**Consultation Response from Trees Planning,
 KC Trees**
**2019/92940 Land west of, Ashbrow Infant and Nursery School, Ashbrow Road, Ashbrow,
 Huddersfield**
**Erection of 161 residential units including a 50 unit extra care facility (all class C3) and public
 open space**
Date Responded: 07/10/19 Responding Officer: NG
Responding Ref: TPO 04/15

Appendix 1: Site Plan	
Ashbrow Road Huddersfield West Yorkshire HD2 1EX JCA Ref: 13945a/JB	25/07/2018
NOT TO SCALE	
1	Stop location/number
SC1	Section location/number
	Transect route
	Trees
	Hedgerow
	Transect 1
	Transect 2
 Arboricultural & Forestry Consultants

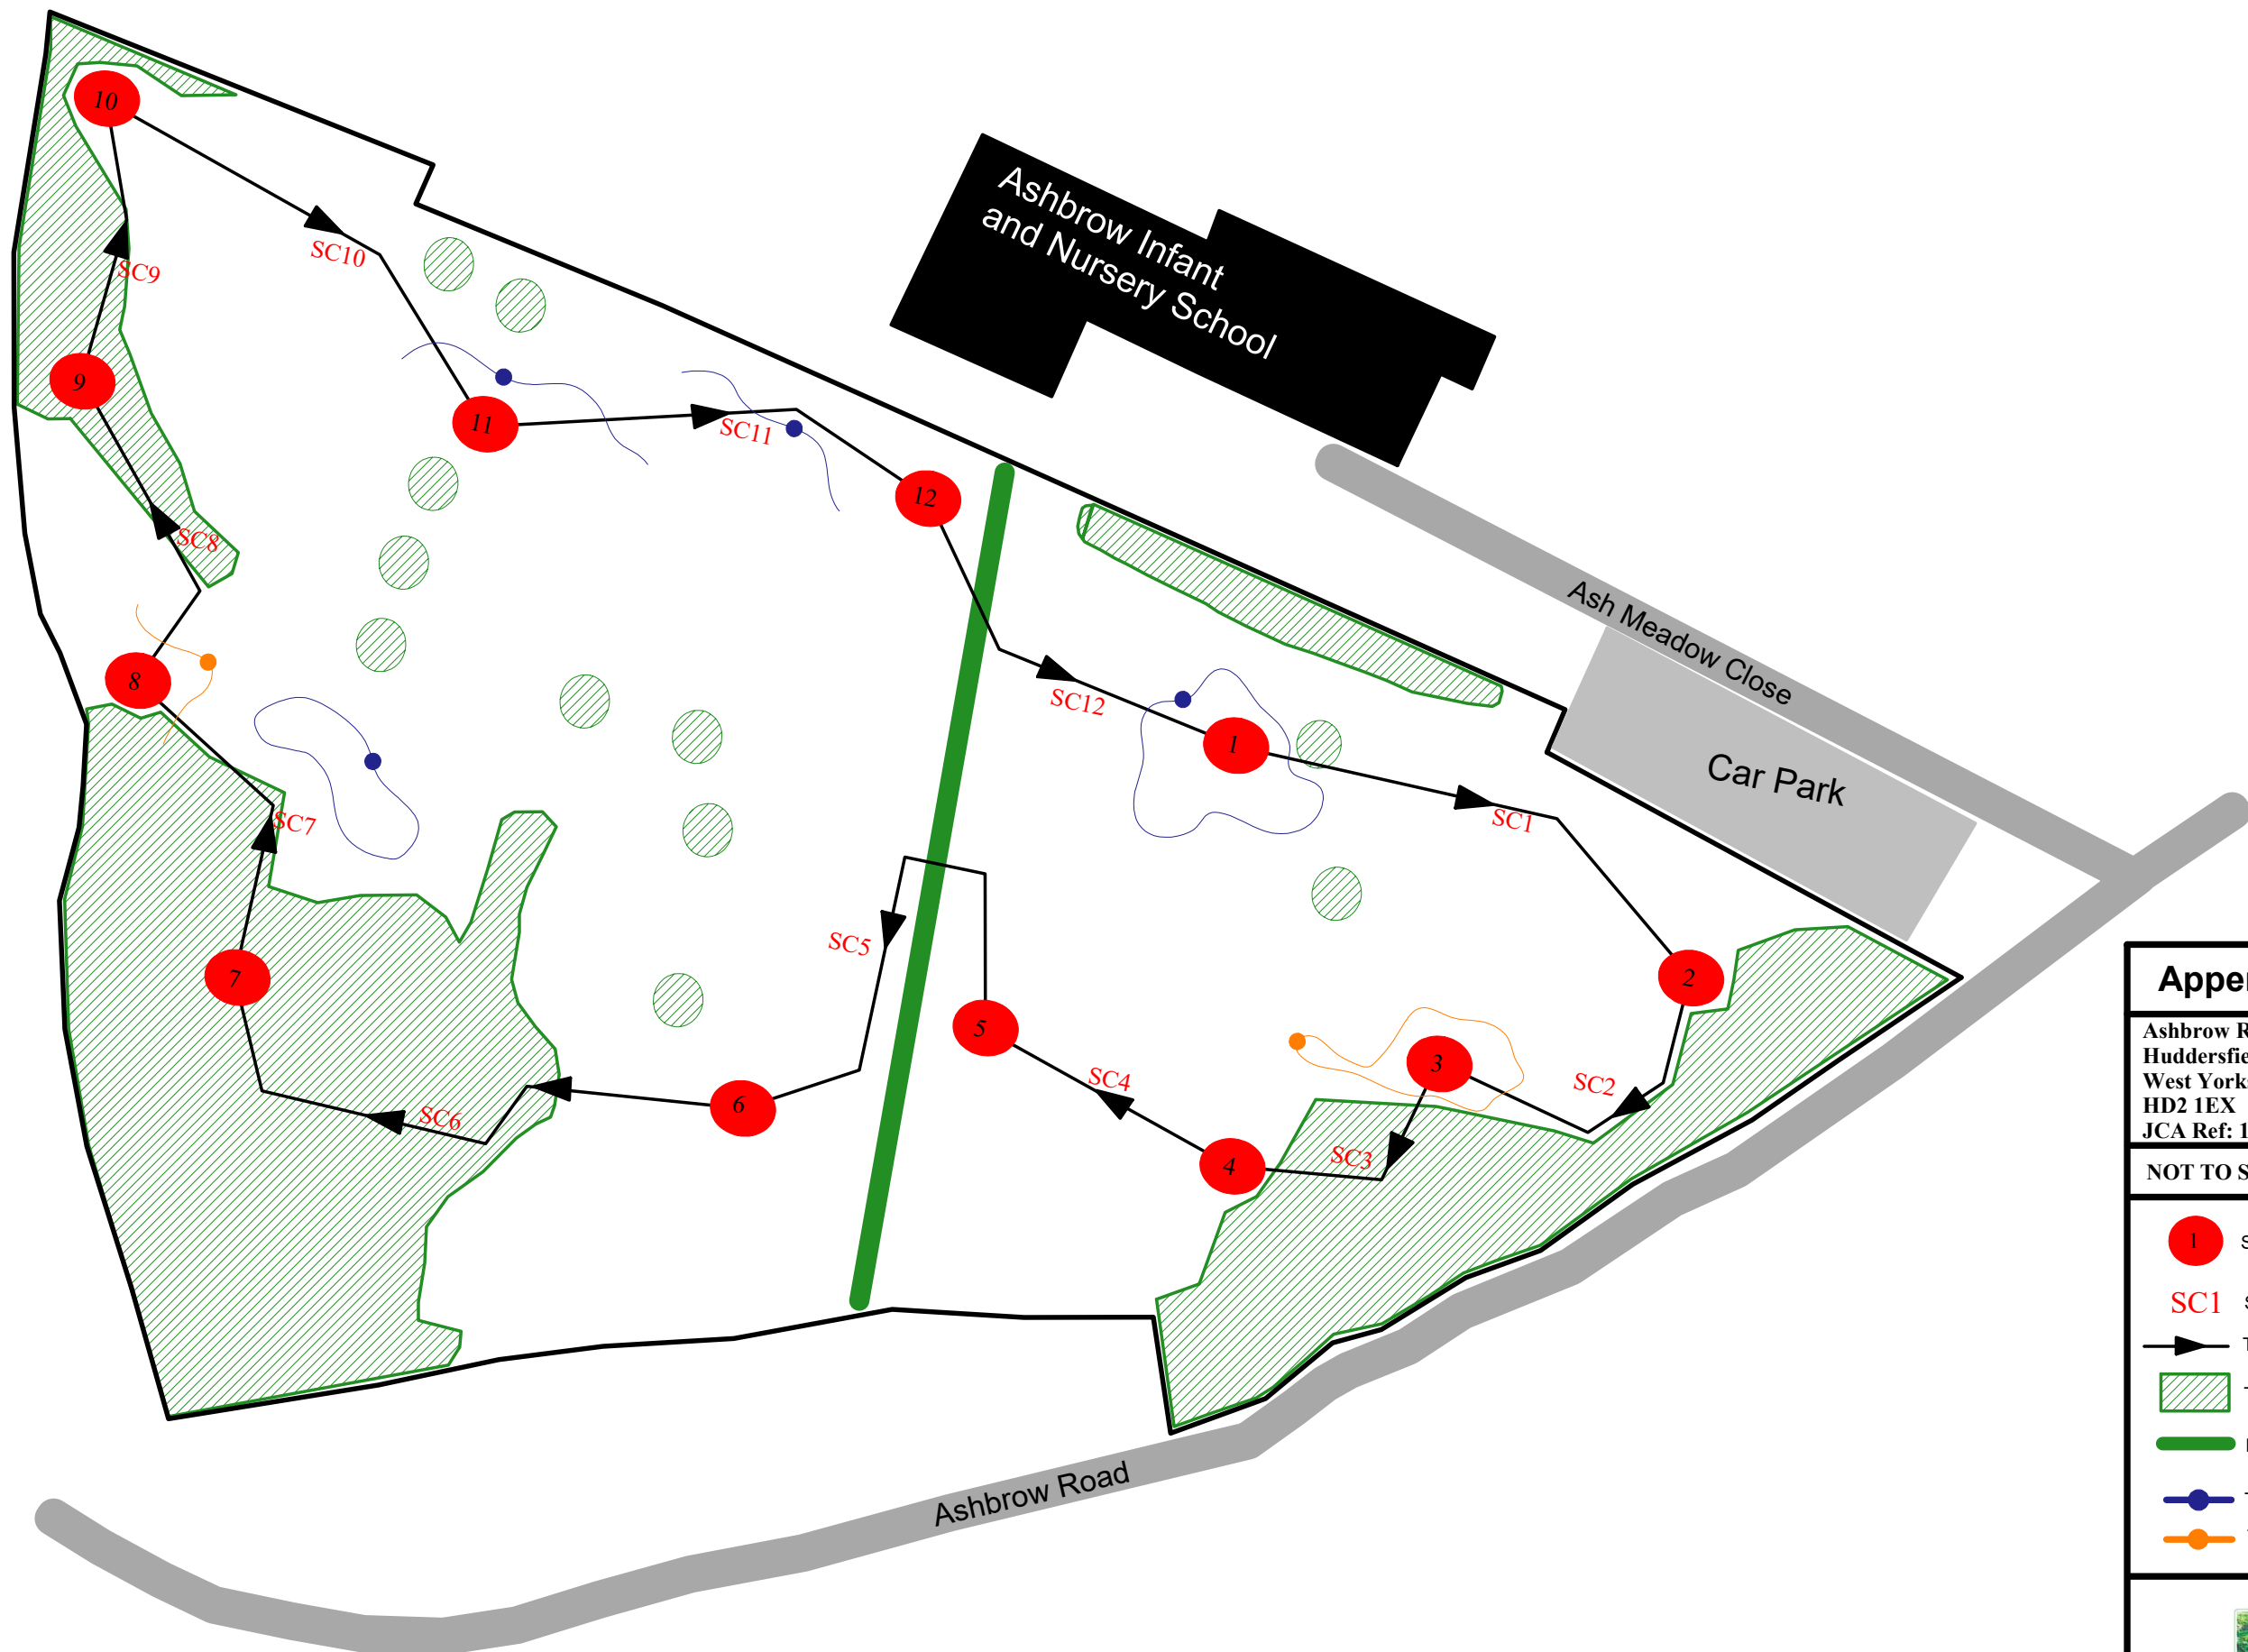
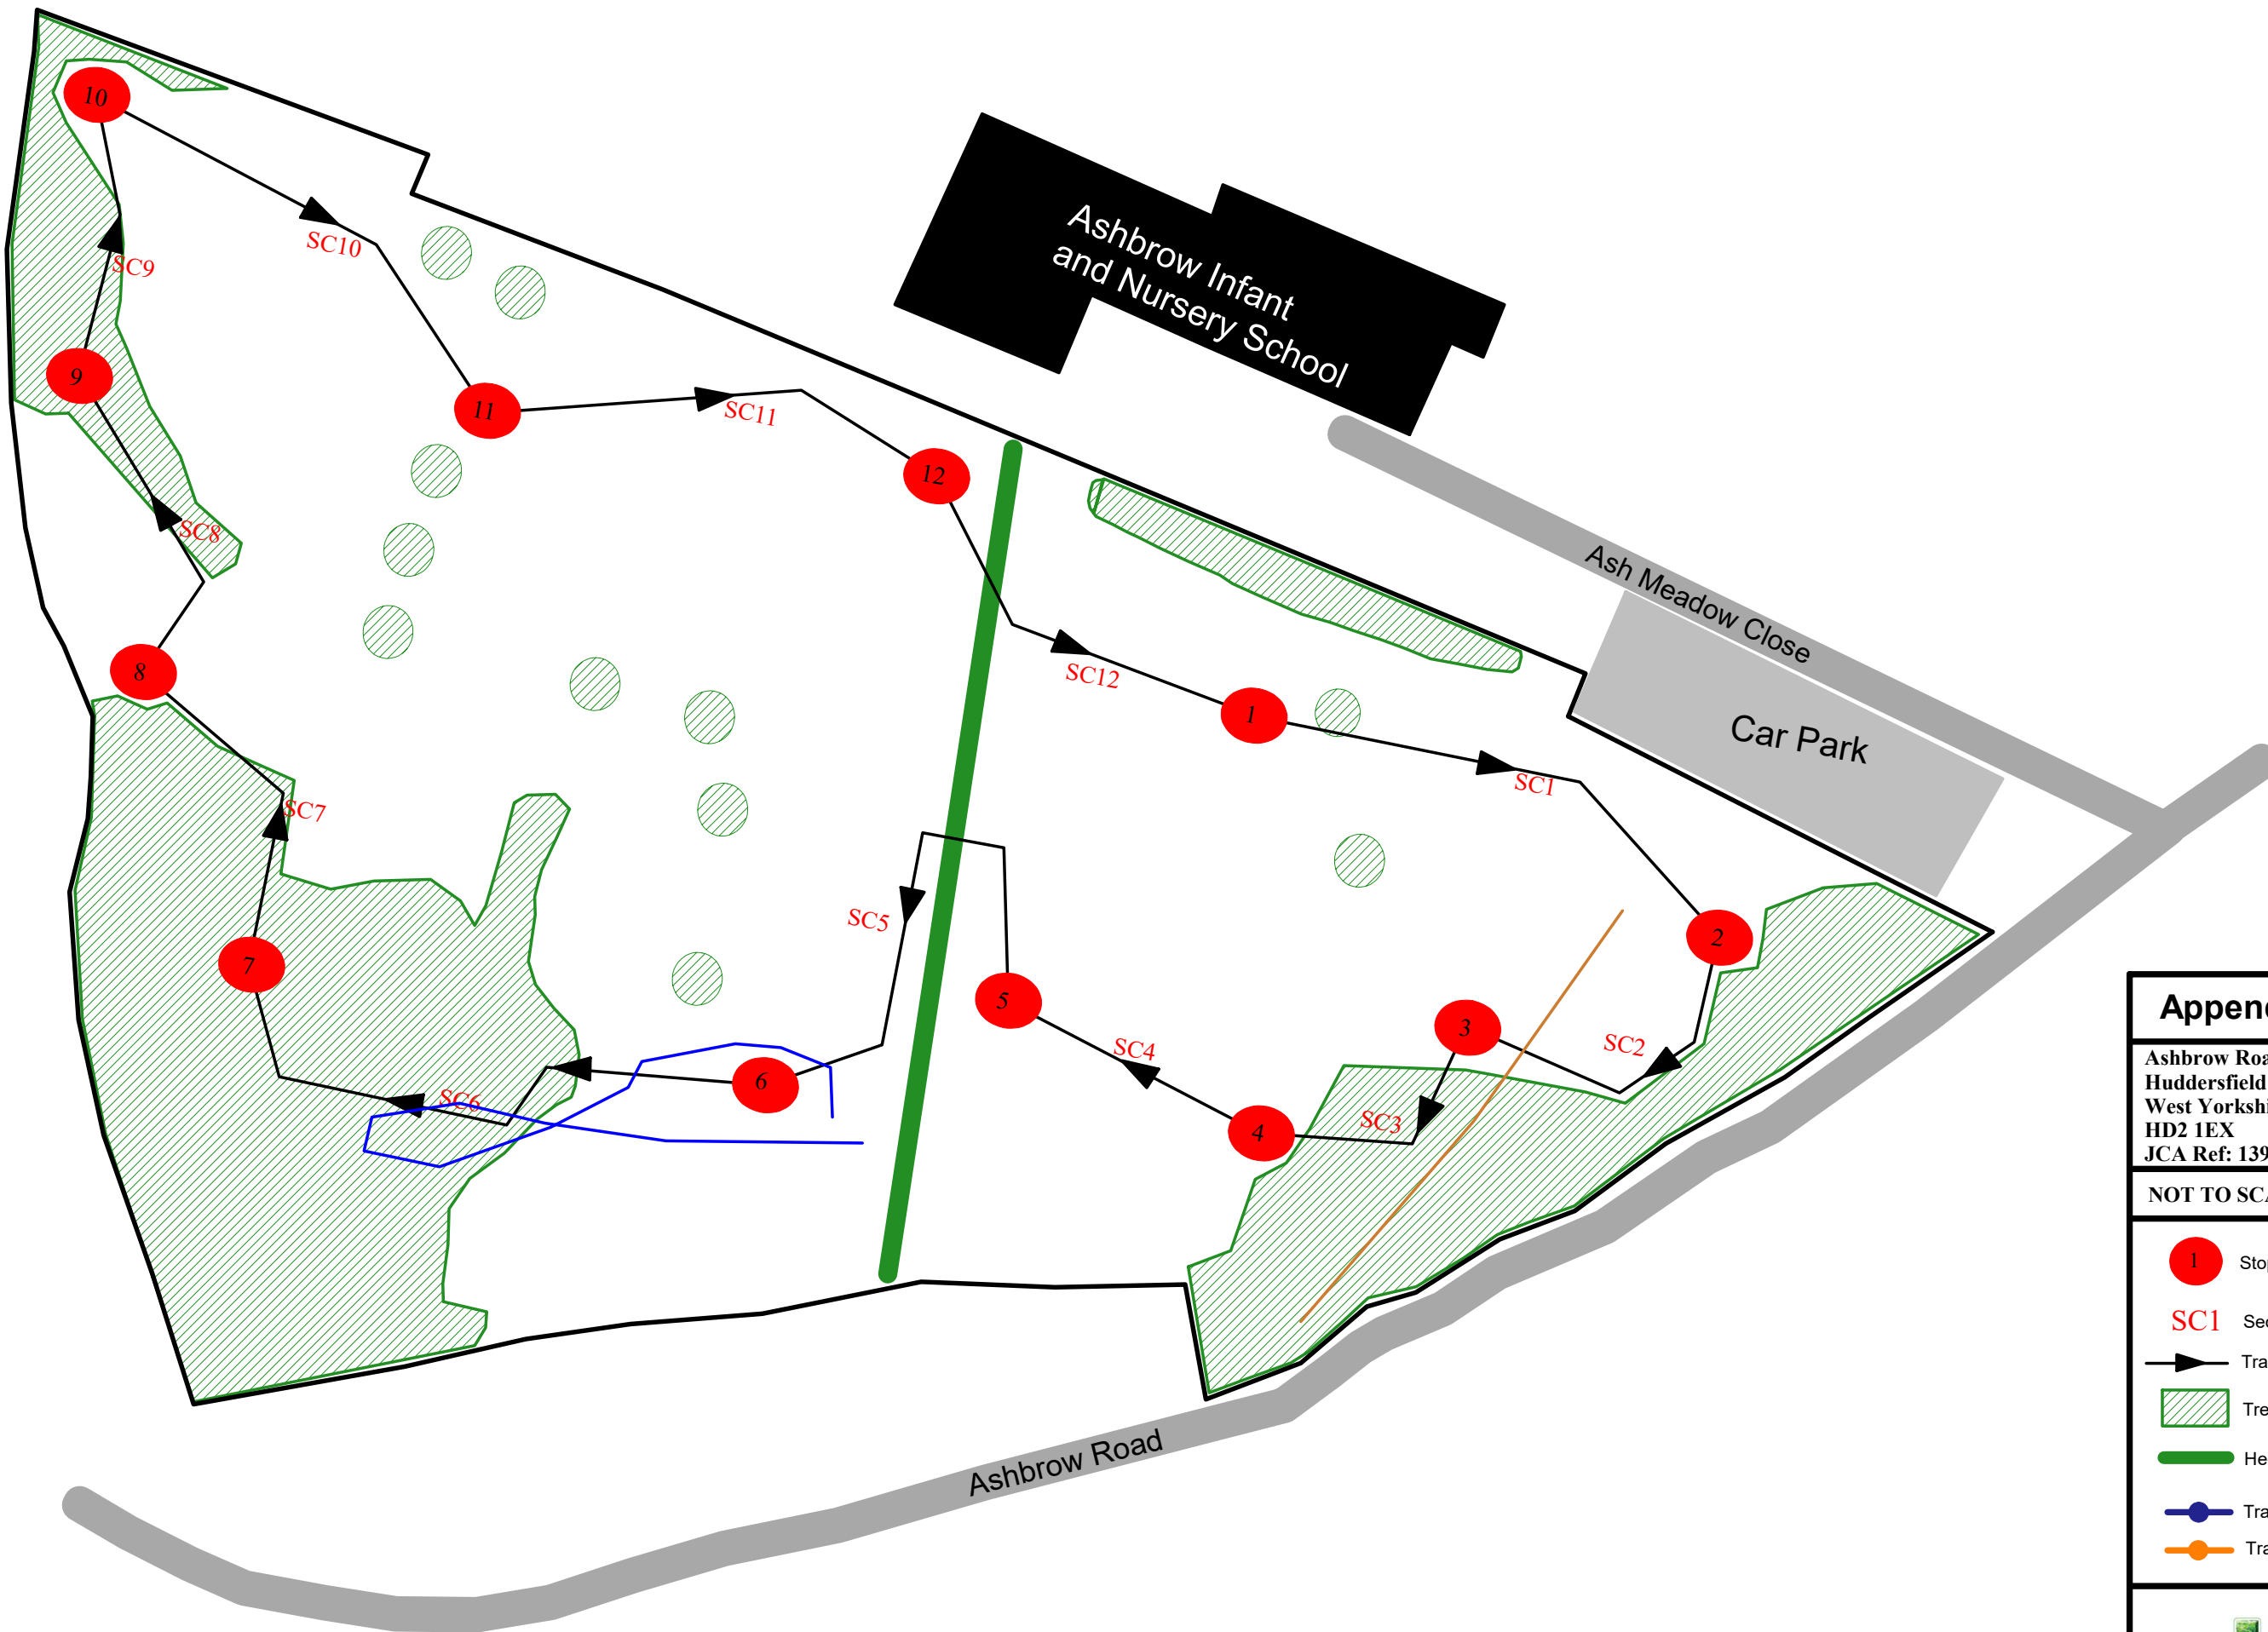
I have no objection to the proposals but am not satisfied with the tree information provided to identify which trees are to be retained and for managing the risk to those retained trees. The Arboricultural Impact Assessment Plan – Appendix F, does not accord with the submitted layout for the site and appears to require more trees than necessary to be removed. The tree removals identified on the Proposed Site Plan, A001 rev Y, are acceptable.

As such I would not want the submitted arboricultural information to be included with the approved documents as they need updating. In order to avoid holding up the application a condition for a site specific Arboricultural Method Statement and Tree Protection Plan, in accordance with BS 5837 could be added to any approval of this proposals.
